FILE NOTE

Re: Meeting – GPT Site – Mamre Road Precinct

The subject development was discussed at a VC meeting chaired by Bruce Colman (Urbis) on 3/08/2020.

E2 CORRIDOR ALIGNMENT PLAN
SCALE 1:500

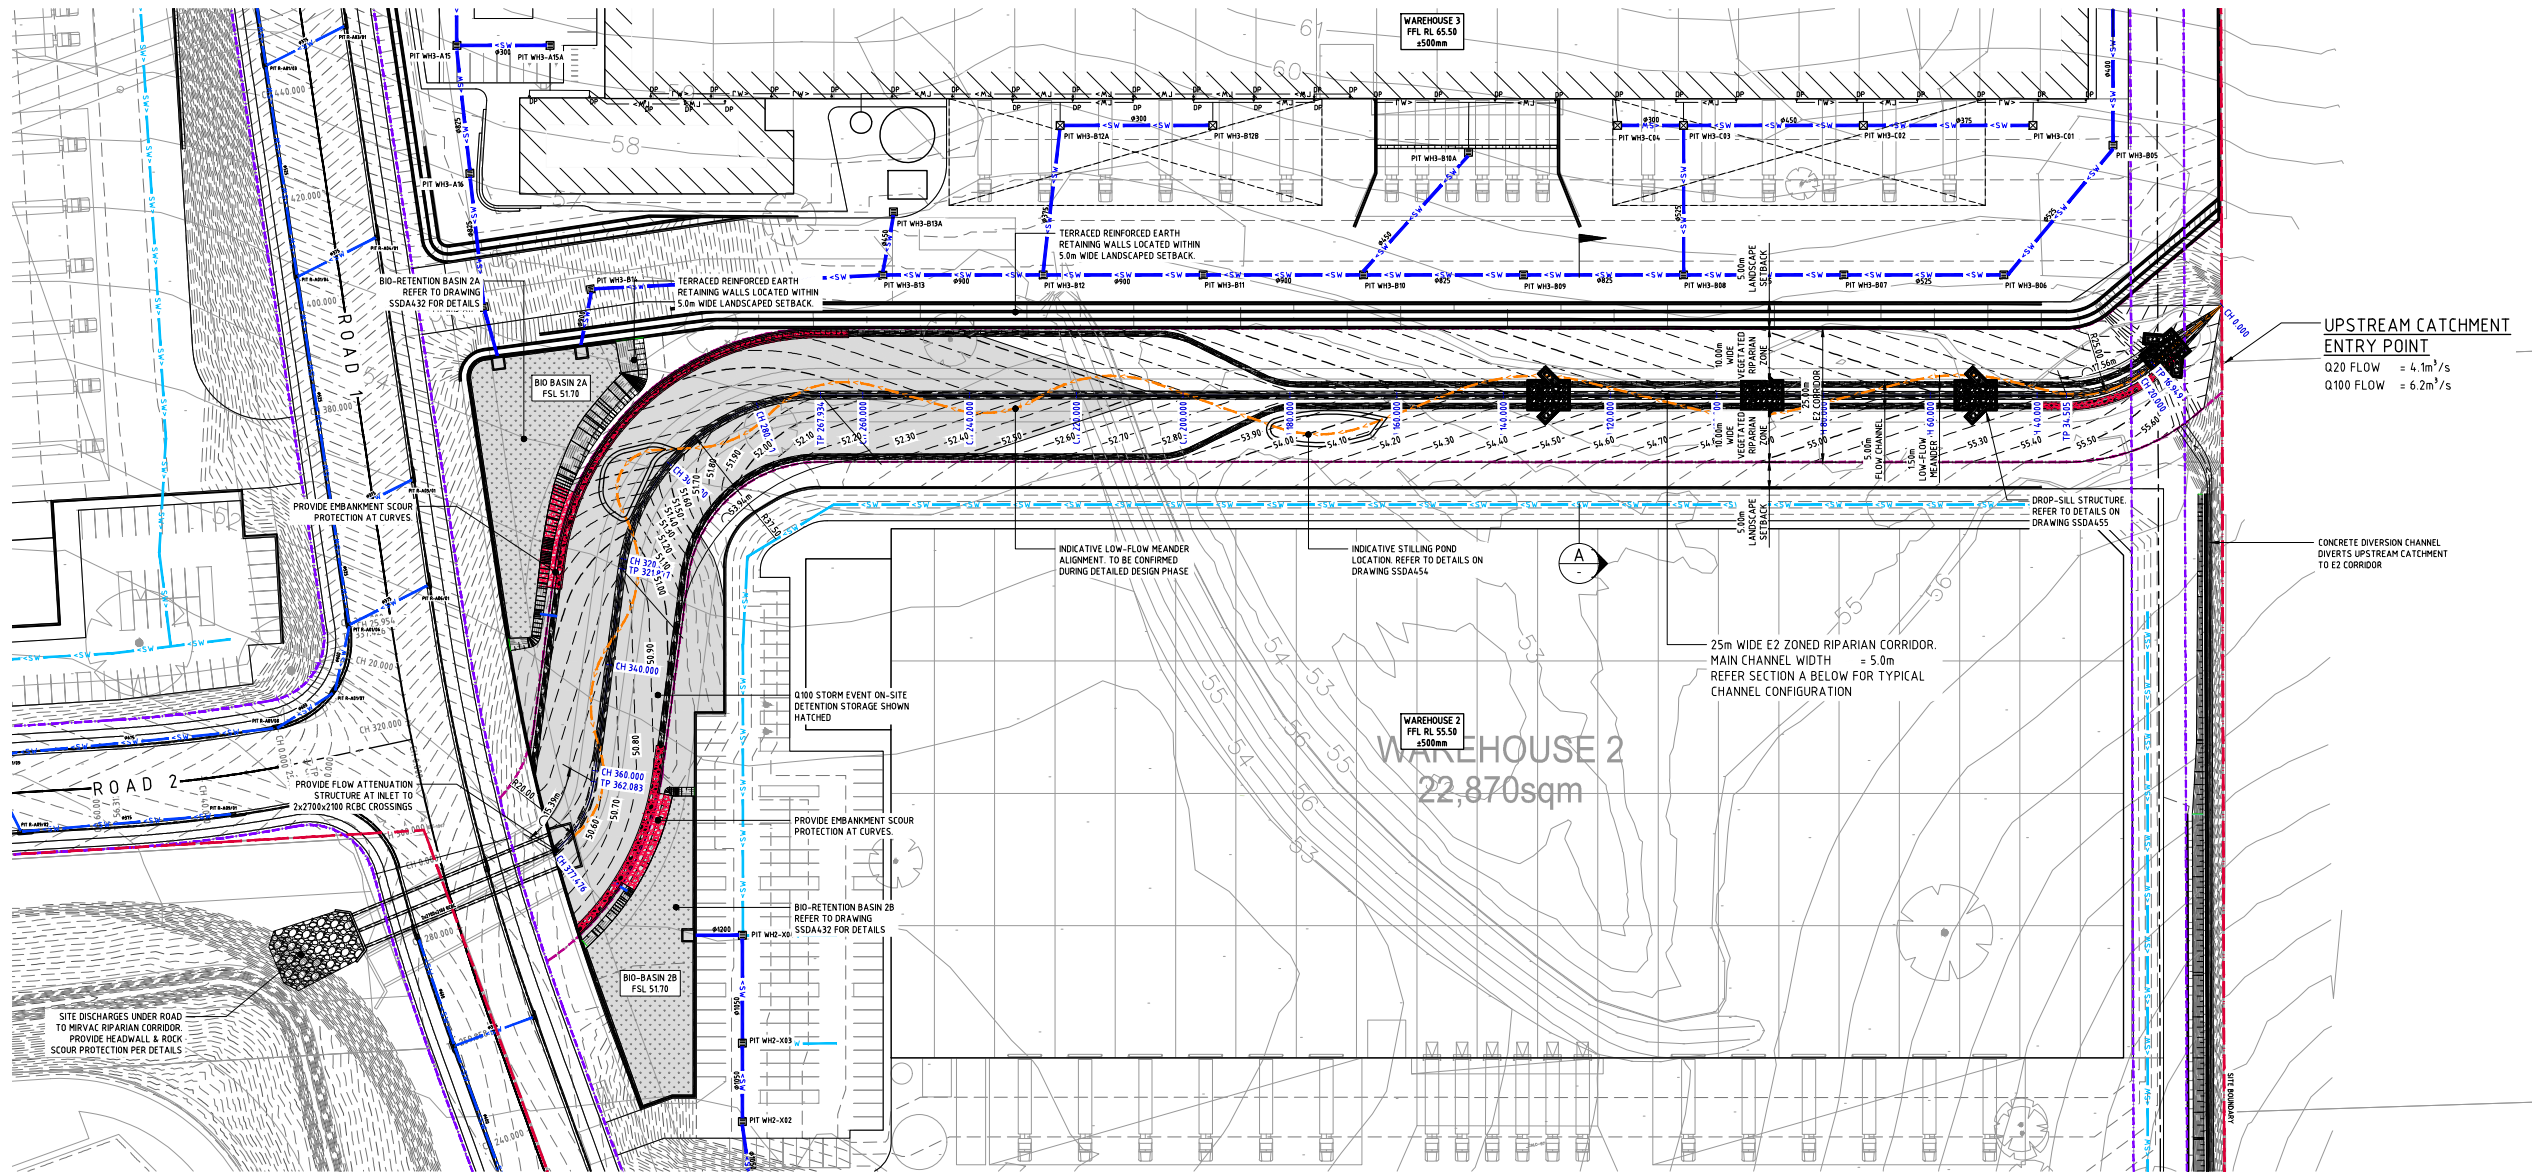
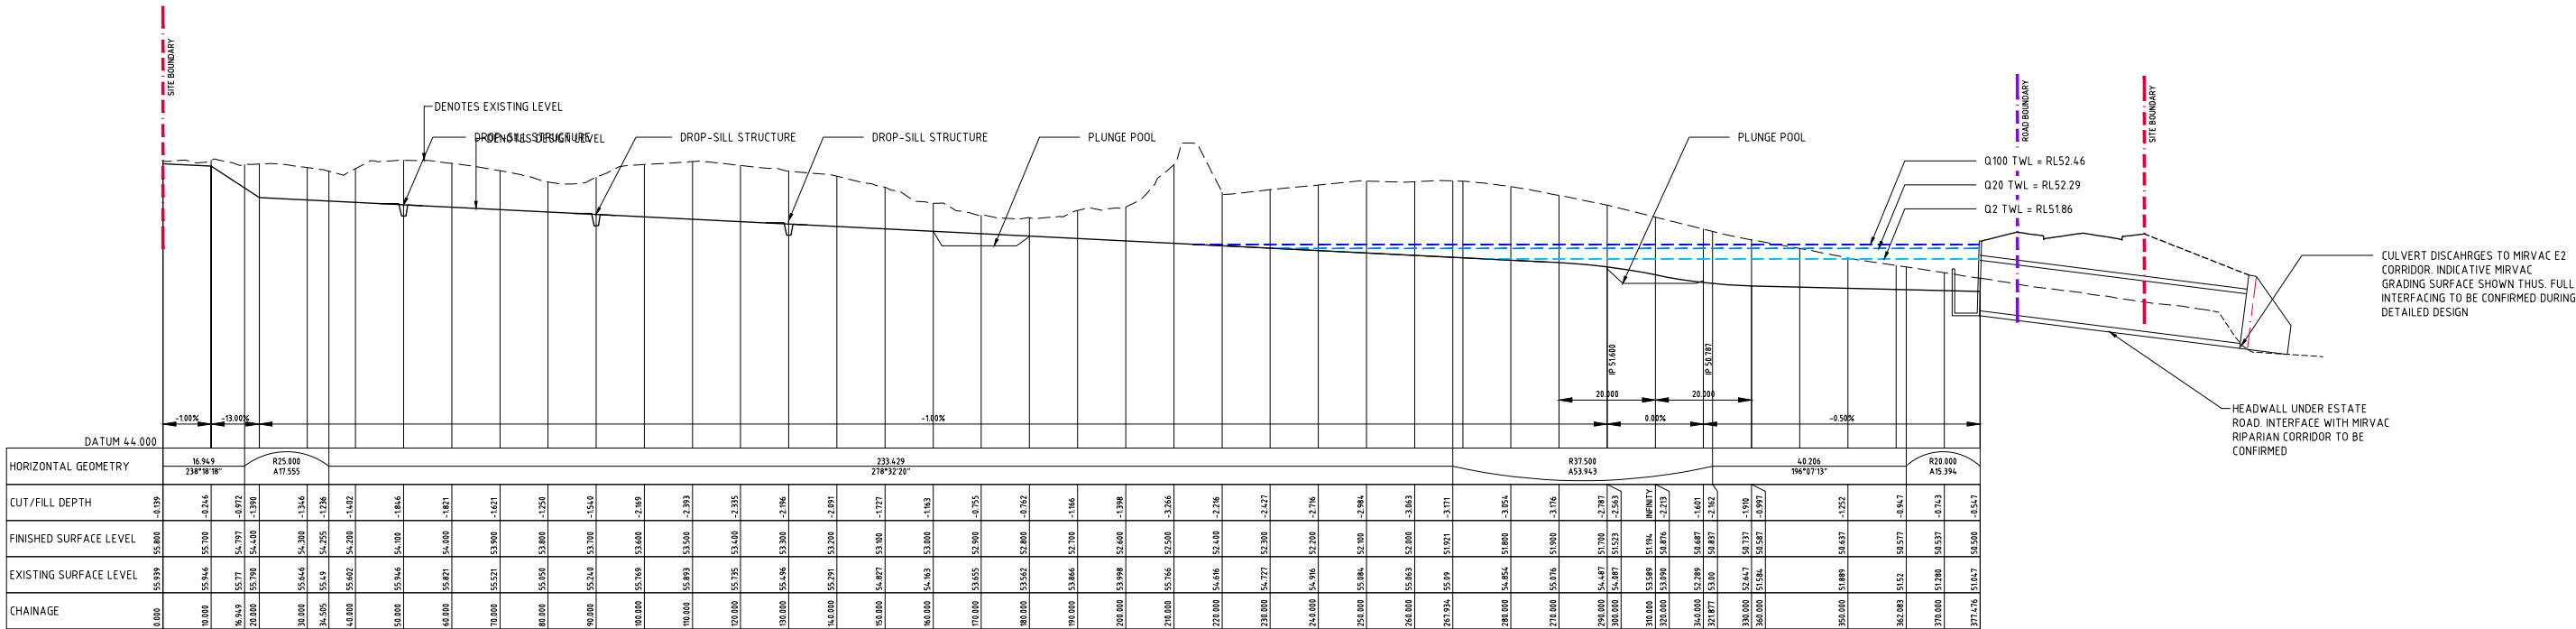
- NRAR is in general agreement that the proposed reconstructed watercourse within the GTP site can be realigned. Realignment should not include 90 degree sharp meanders. The alignment should mimic natural stream design.

- Realignment is to minimise impact to remnant vegetation areas upstream of the site.
- NRAR requires details of the realignment on up and down stream sites prior to signing off on final realignment.

- NRAR does not support the reduction in the corridor width from 40m to 20m in the upstream reach within the GPT site. It is noted that the reduction of stream ordering due to the removal of upstream 1st order watercourses is contrary to the requirements of the NRAR CAA Guidelines for riparian corridors.
